Your Ref: OWPC24901
Our Ref: BR/306/19/HH 01-11-2019
Please ask for:
Finlay Gardner

Two storey side and rear extension, single storey rear extension & replacement front porch.

28 Arun Road Bognor Regis

Thank you for your internet representation made on 18th November 2019 which has been recorded as '**an objection**' with the comments as follows:

CLIENT	Mrs G Curtis	DRAWING	002 Proposed Plans & Elevations		
SITE	28 Arun Road, Bognor Regis	DATE	31 10 19	AUTHOR	AH
PROJECT	Proposed Extensions & Alterations	SCALE	1: 100 @ A3	STATUS	PRE PL

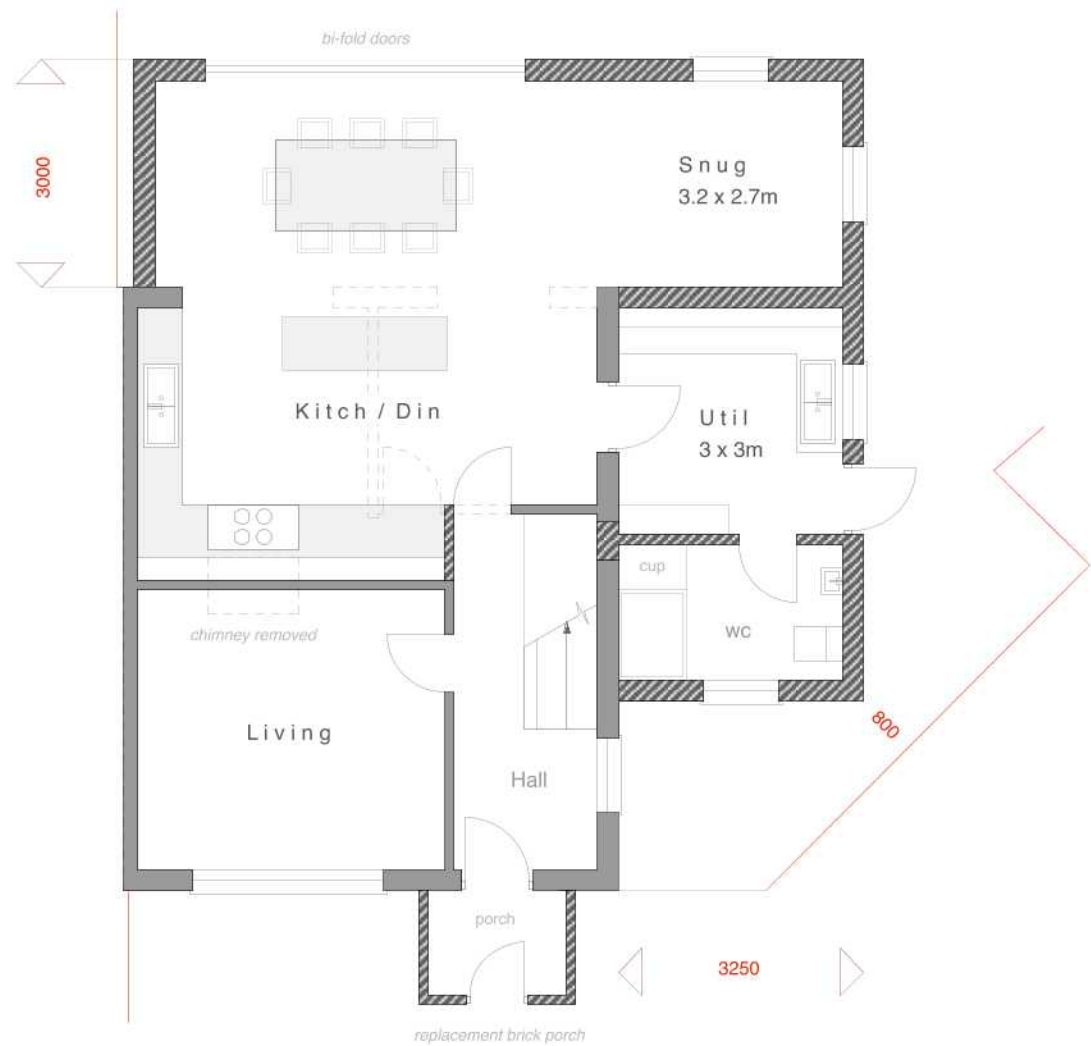
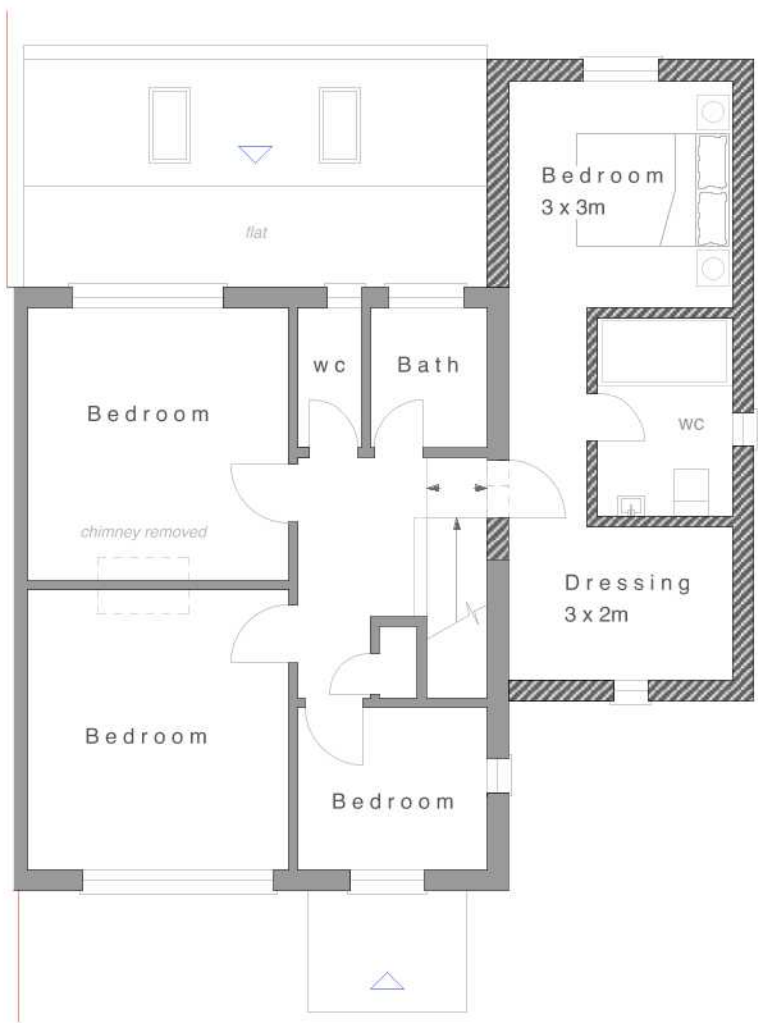
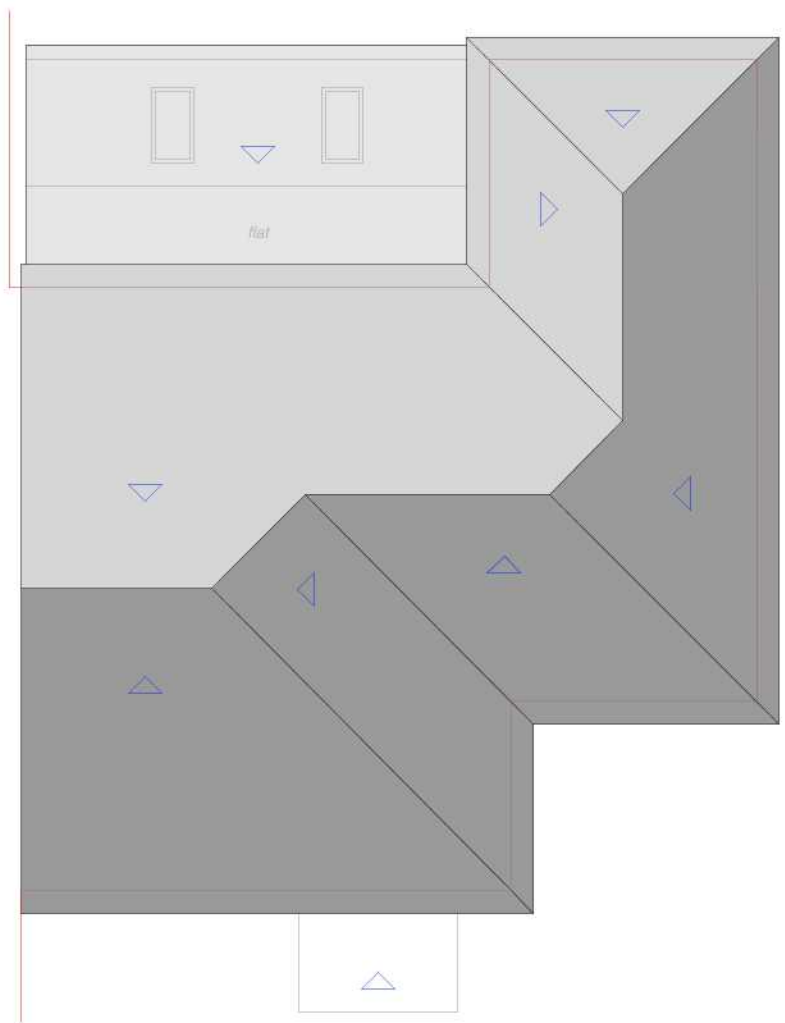
Our property, no.26, is on the right hand side attached to no.28. The planned large extension double storey and excessively tall single storey on the rear of the property will block out daylight to our bedroom, kitchen and dining room.

Additionally, the extension will overshadow our garden and invade our privacy as the proposed new bedroom window will be sticking out into the middle of their garden, and the view from their bedroom window will look straight into and all around our garden.

There has been no gap left between boundary's for both the building and maintenance of their property also guttering overhang onto our garden.

The extension is much larger than any other existing extension in the road. This extension effectively doubles the size of the house as you can see from the plans.

All other extensions are less than 3 metres high and flat roofed. No.28's extension is over 3 metres high and is not a flat roof. It will be the only double storey extension in the road and is not in keeping with any other surrounding property.

It is overbearing, excessive, unduly dominant and out of character for this road.
